Kirklees Council  
Planning and Development Service  
PO Box 1720  
Huddersfield  
HD1 9EL

Date: 09-Sep-2025  
Our Ref: 2025/90119

**Discharge of details reserved by conditions 3 (Phase 2 Report), 4 (Remediation Strategy), 7 (CEMP), 19 (Window Details), 21 (Roofing Materials), 22 (Walling Materials), 23 (Mortar Specification), 24 (Materials (plot 15)), 29 (Boundary Treatment) on previous permission 2021/93006 for conversion of existing barn to form 8 dwellings, erection of 9 dwellings, demolition of redundant agricultural buildings and associated works (Listed Building within a Conservation Area)  
Yew Tree Farm, The Village, Farnley Tyas, Huddersfield, HD4 6UQ  
Application Number: 2025/90119**

PROJECT TITLE				YEW TREE FARM			
DRAWING TITLE				BOUNDARY TREATMENT DETAILS			
SCALE	DRAWN	CHECKED	PROJECT REFERENCE				
1:200	JH	JH	ODS_20/294				
PAPER SIZE	DWG NUMBER	DATE	REVISION				
A3	(20)004	25/3/21	B				
CLIENT				RADCLIFFE DEVELOPMENTS (FARNLEY)

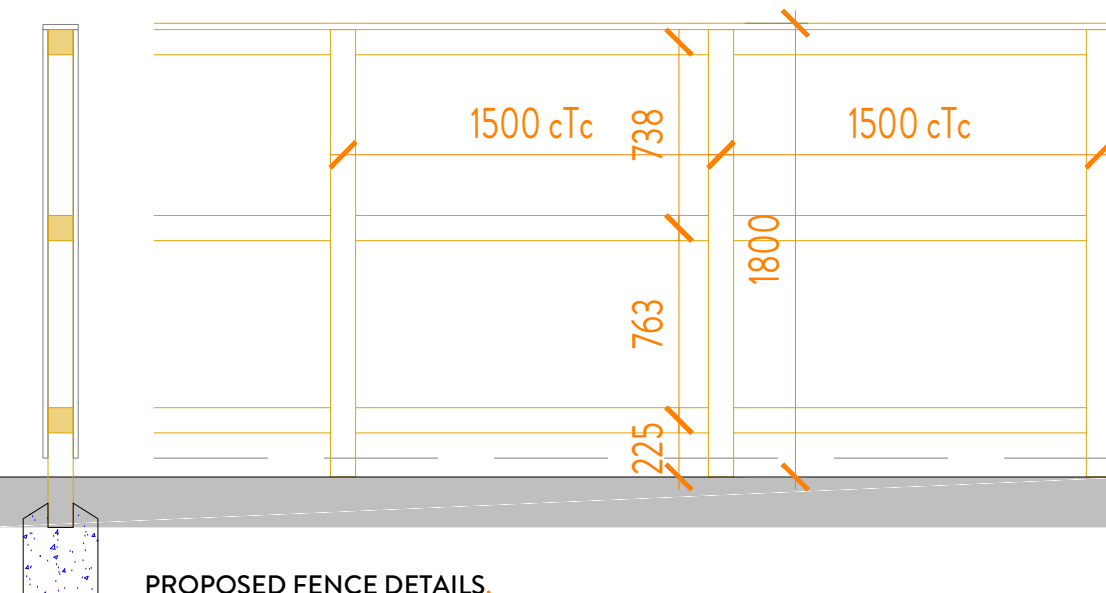
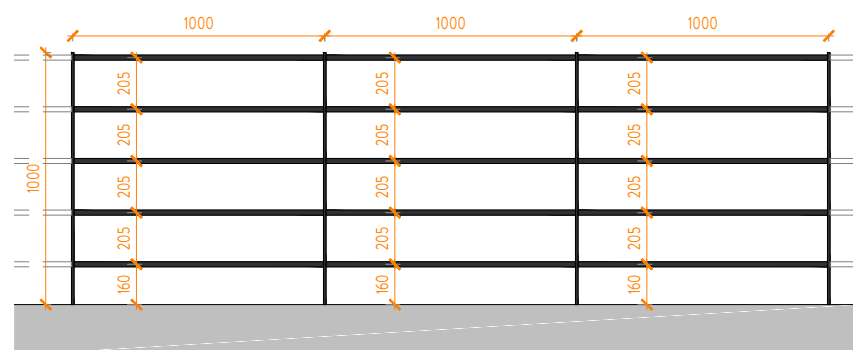
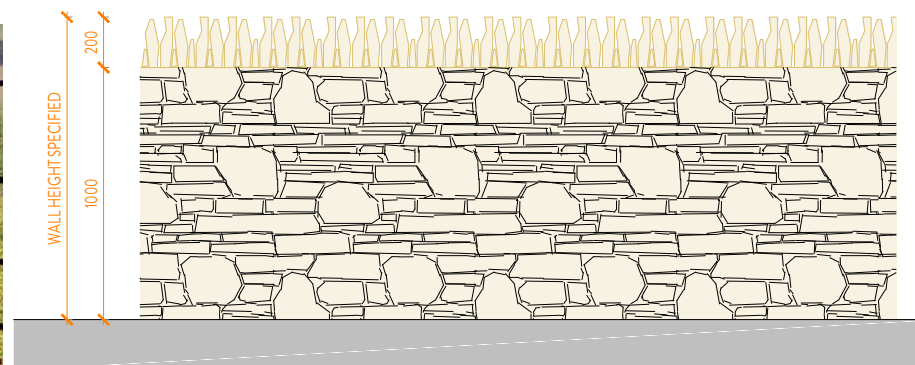
The submitted information does not meet all the requirements of Condition 29, and therefore Condition 29 cannot be discharged at this time.
